From: Sarah Sutcliffe <[REDACTED]>
Sent: 04 April 2022 09:45
To: Simon Davis
Subject: RE: AL/28/22/DOC (Condition 10) & AL/29/22/DOC (Condition 11) (Wing's Nursery, Lidsey Road)

Condition 11:

Condition 10:

Engineers Comments Regarding Condition 10

TYPICAL TANK LINING DETAIL
(Scale 1:10)

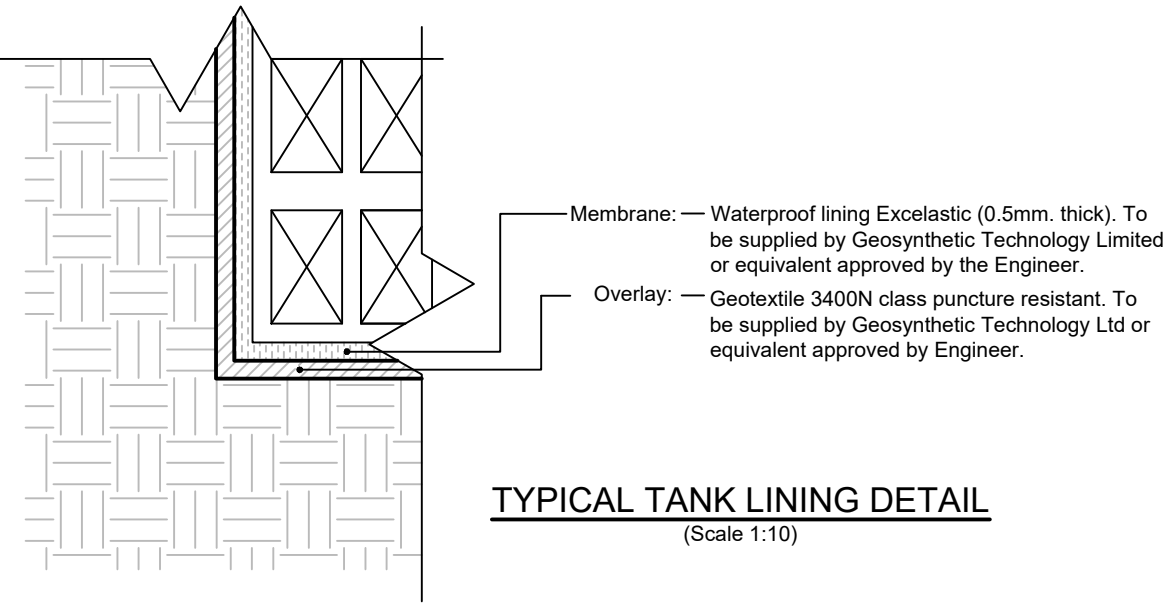
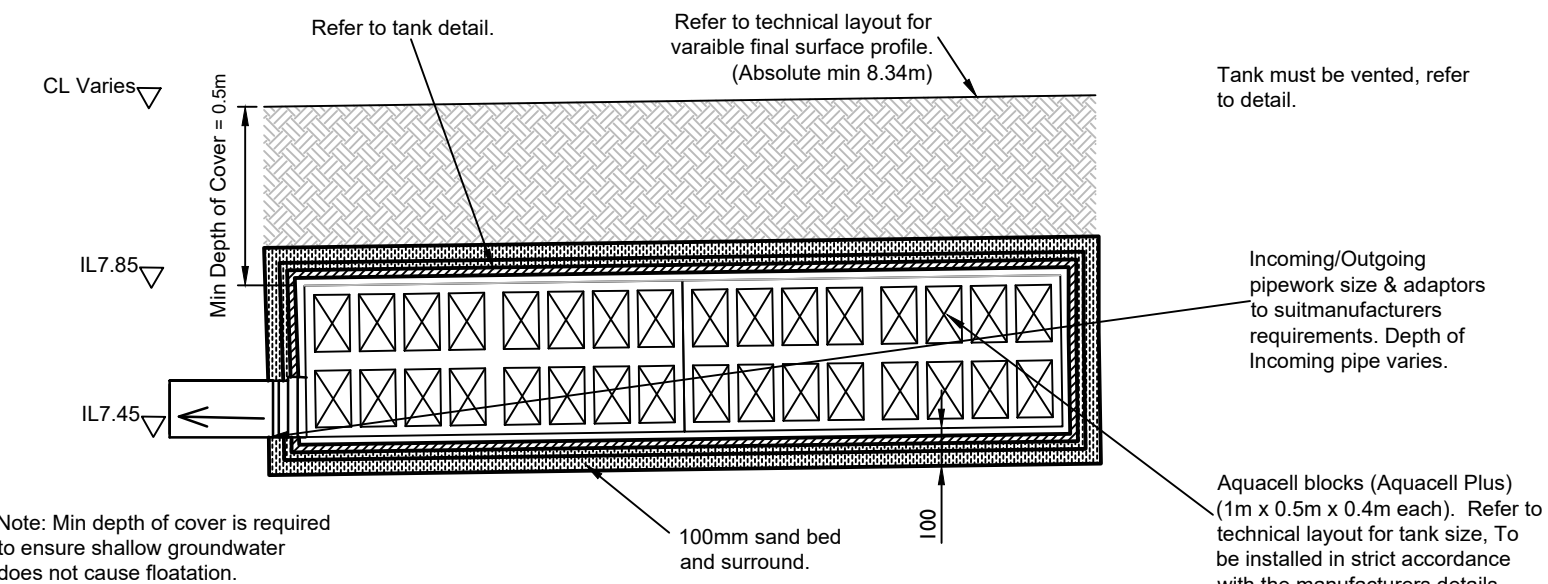
14. *Please detail overflow level on S23 construction detail drawing. The construction detail now specifies the overflow location and size.*
15. *Please detail membrane around attenuation tank on construction detail drawing. Please make detail site specific. The construction detail is now updated.*

PLAN
FLOW CONTROL CHAMBER S102
(Scale 1:20)

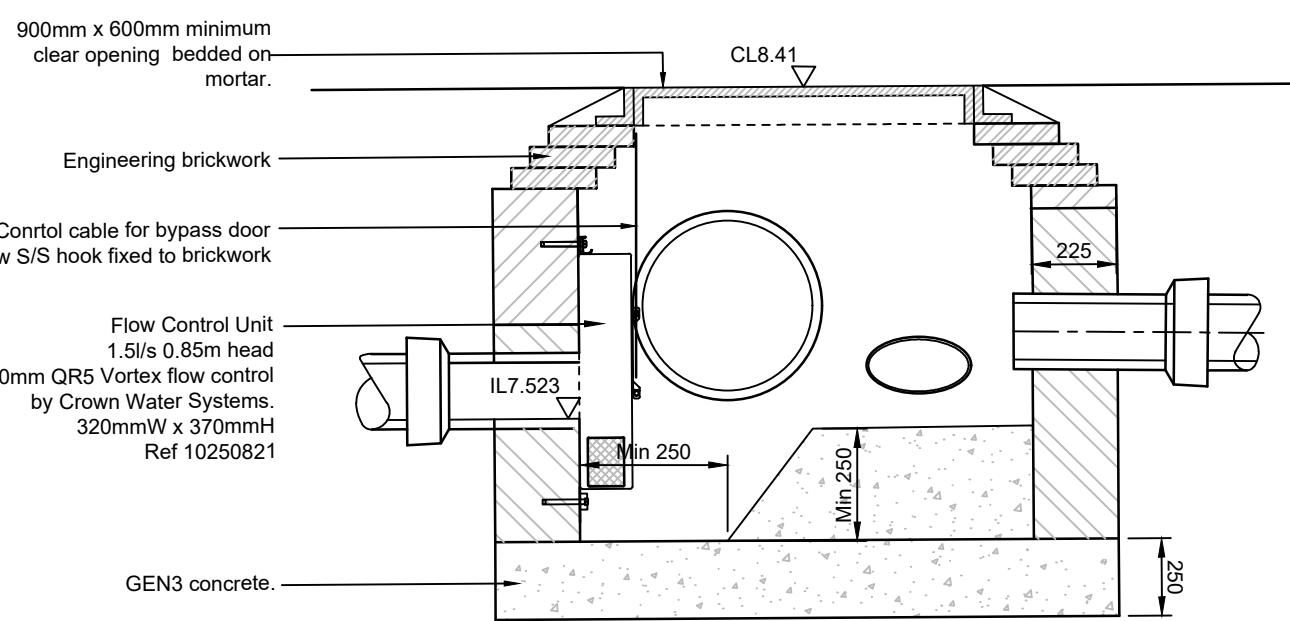
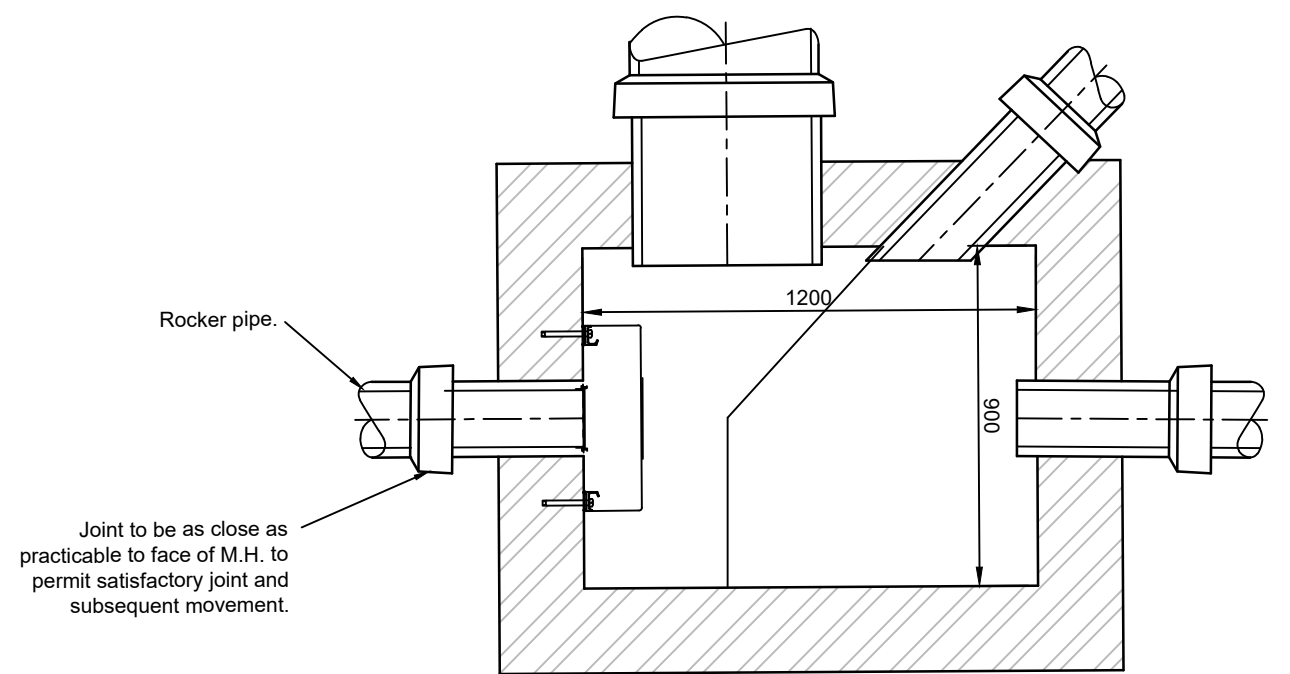
12. *Please provide flotation calculations for cellular storage and attenuation basin. Please see attached calculations in directory 05.*
13. *Please provide data sheets to evidence flow control devices for S102 and S23 will achieve the criteria within the flow model. Please see attached data sheets in directory 07.*

BAGWORK HEADWALL

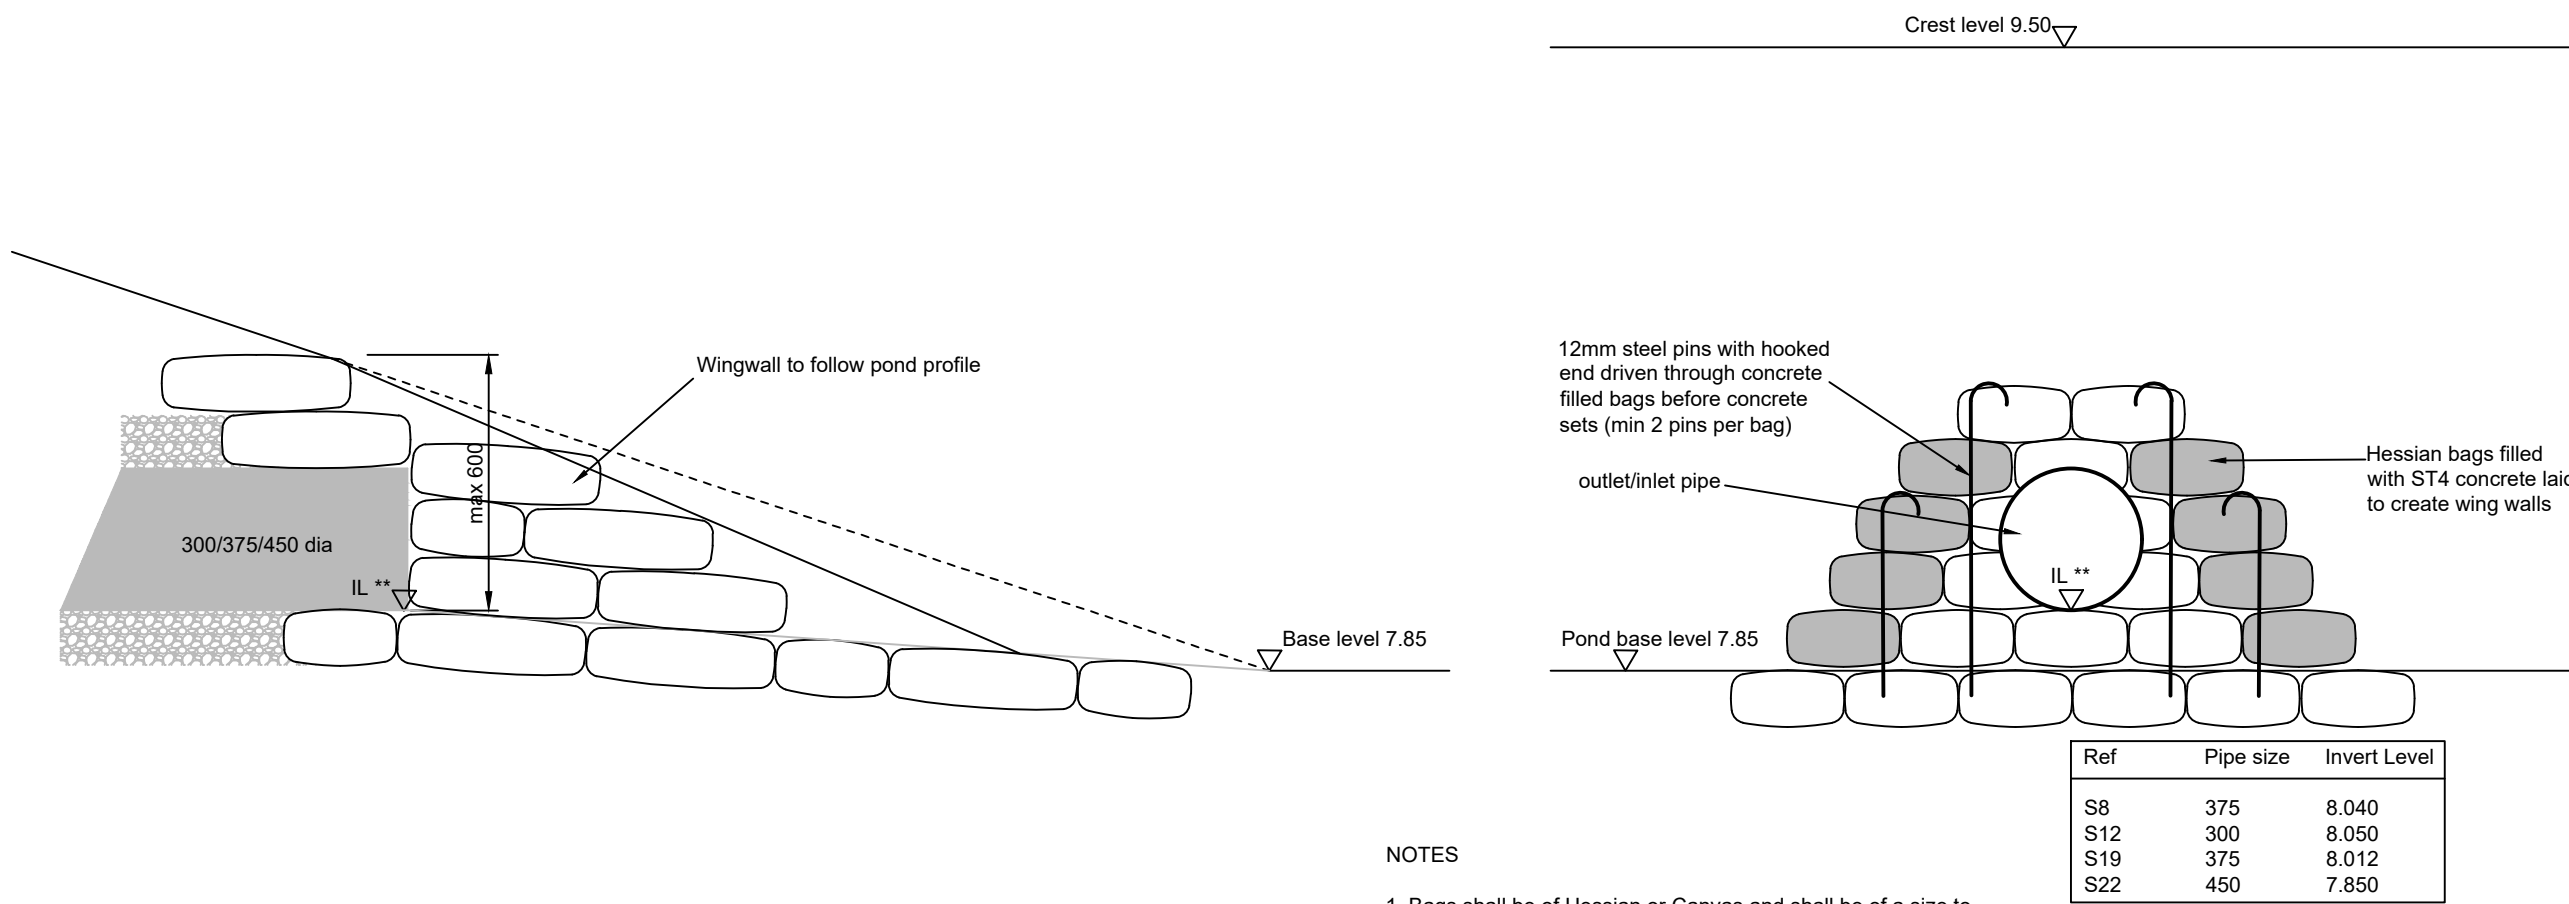
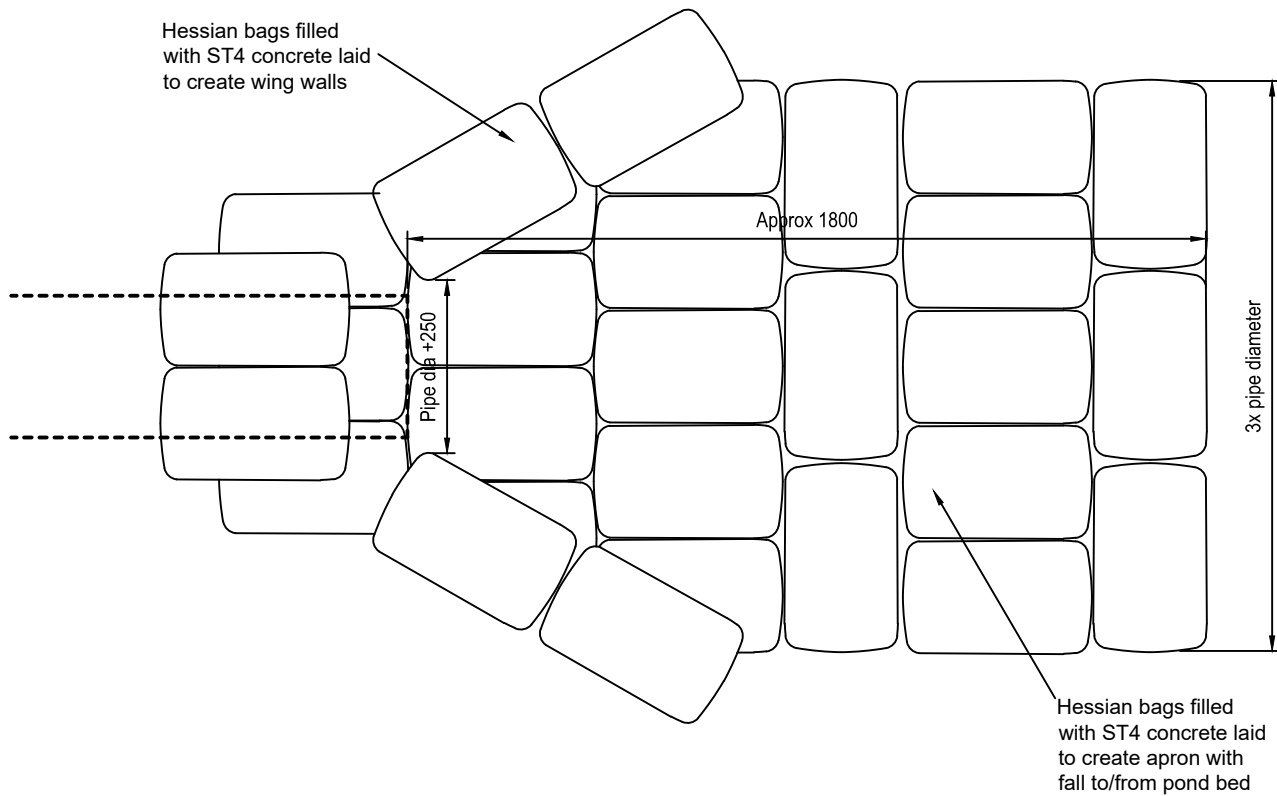
18. *For the bagwork headwalls to the basin- please detail bag size, how full bags are to be with ST4 concrete, how bags are to be compacted, what bond pattern is to be followed, spacing of pins, minimum width of headwalls, etc. Please refer to drawing 15.3.*
